PLANNING AMENDMENT

Application No: H22-1046-14

Description: Demolition and reinstatement of two-storey extension, replacement wooden sash windows, replacement internal floor to one room, removal of external stainless steel boiler flue introduction of a new ground floor window and general refurbishment

Amendment: Changes to window design (dwg. nos. A-238-51A, A-238-53A and A-238-54A)

Drg. No. **A-238-54** Rev. **B**

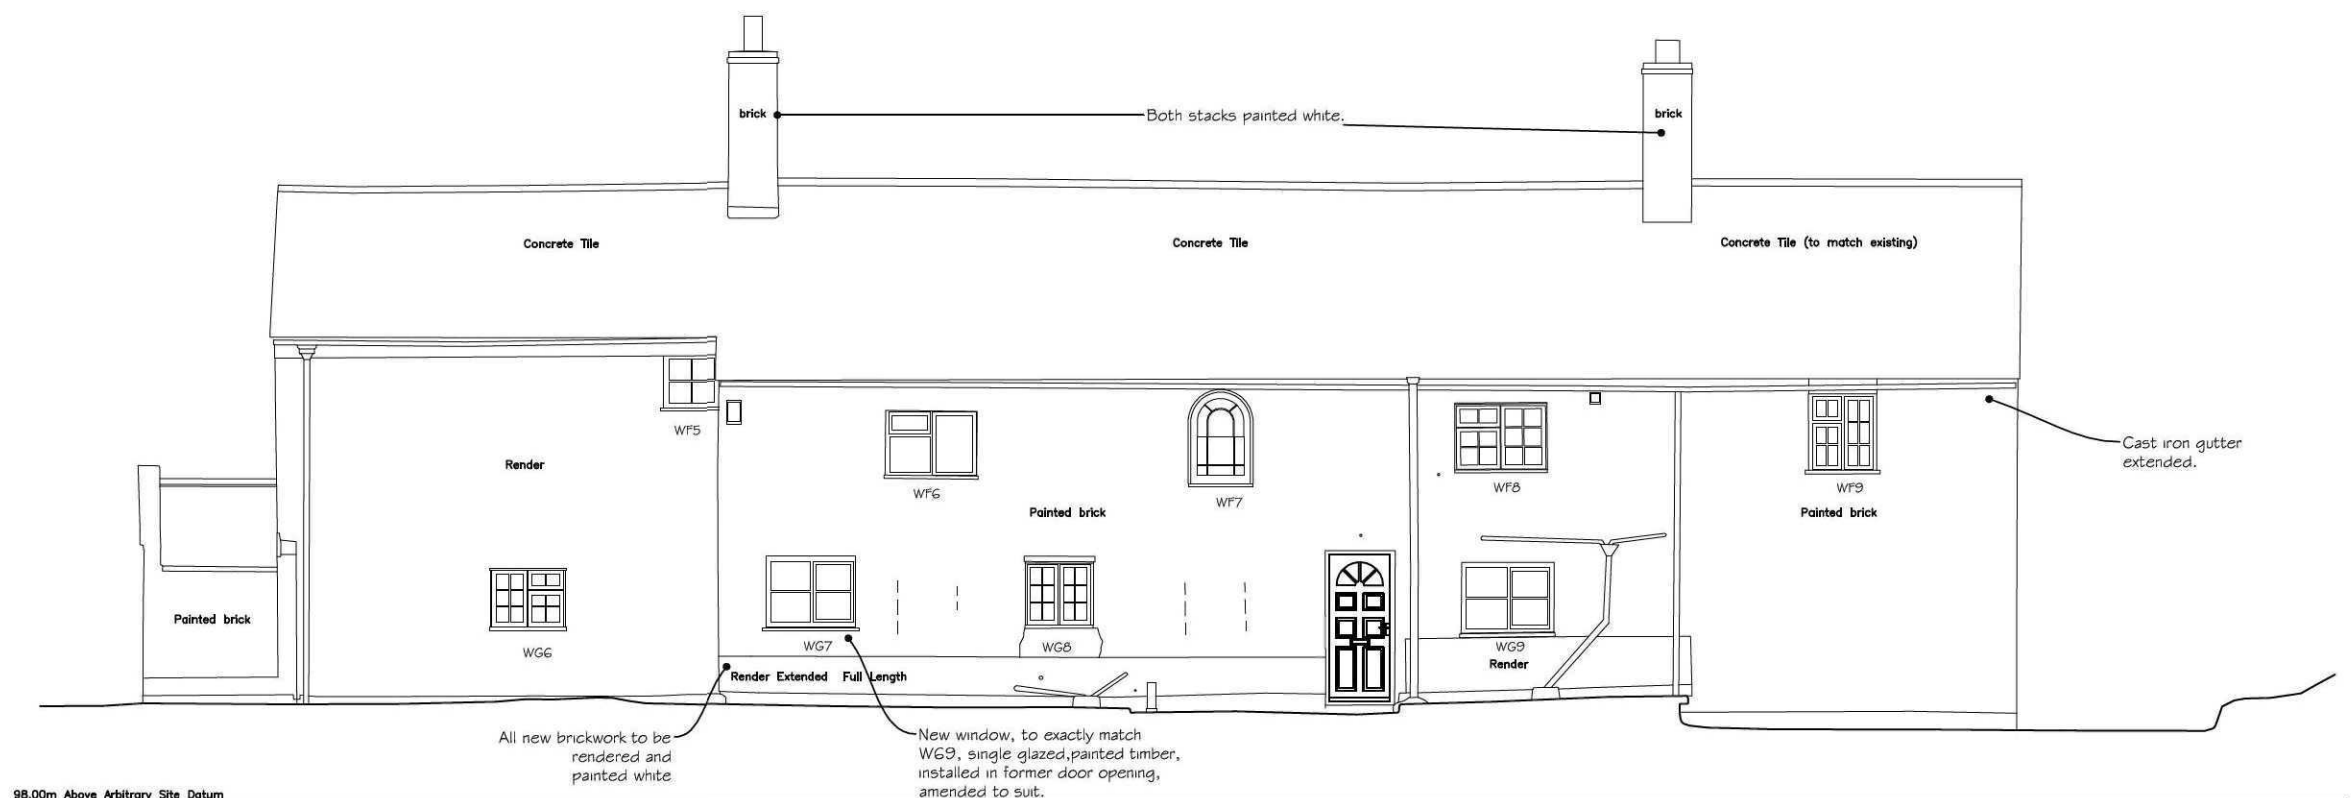
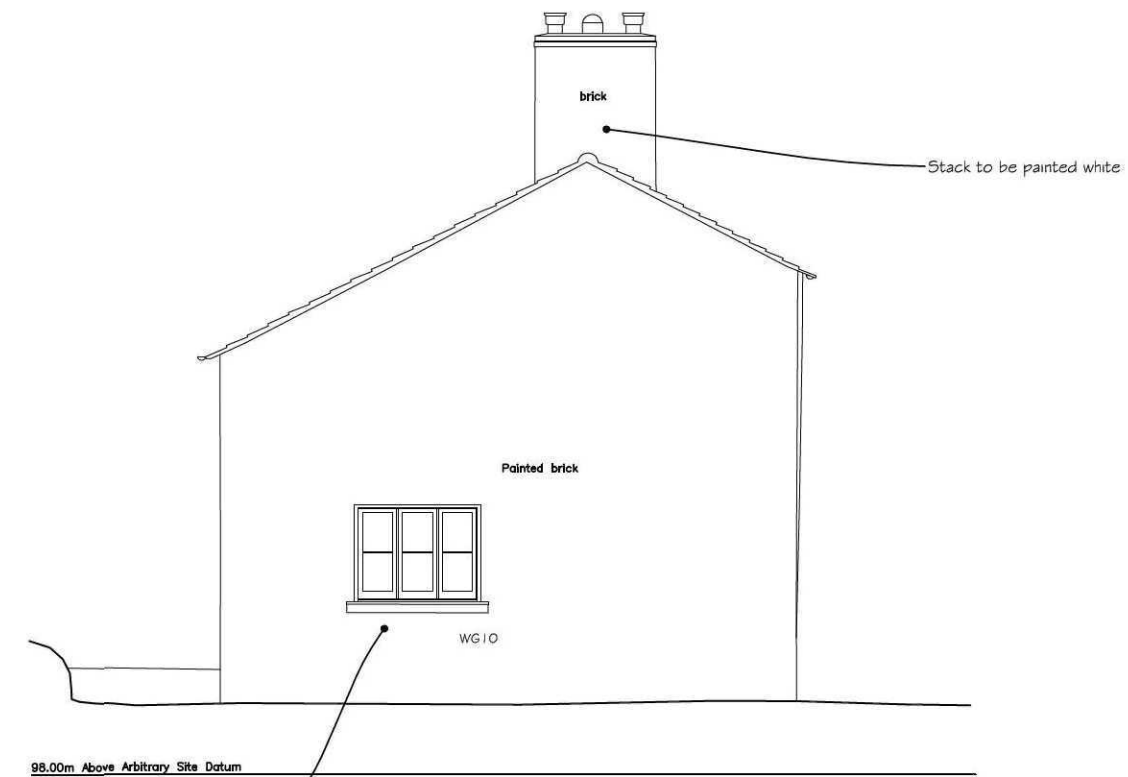
Amendment	1	Date	05-02-2015
Type	CUR	Current Application	
Ref			
Description	Changes to window design (dwg. nos. A-238-51A, A-238-53A and A-238-54A)		
Long Description	Changes to window design: - WG7 on north elevation. - WG10 on west elevation. - Addition of downright on southern elevation. ((dwg. nos. A-238-51A, A-238-53A and A-238-54A))		
Ref		Date	
Value	0.00	Value	0.00
Value		Value	0.00
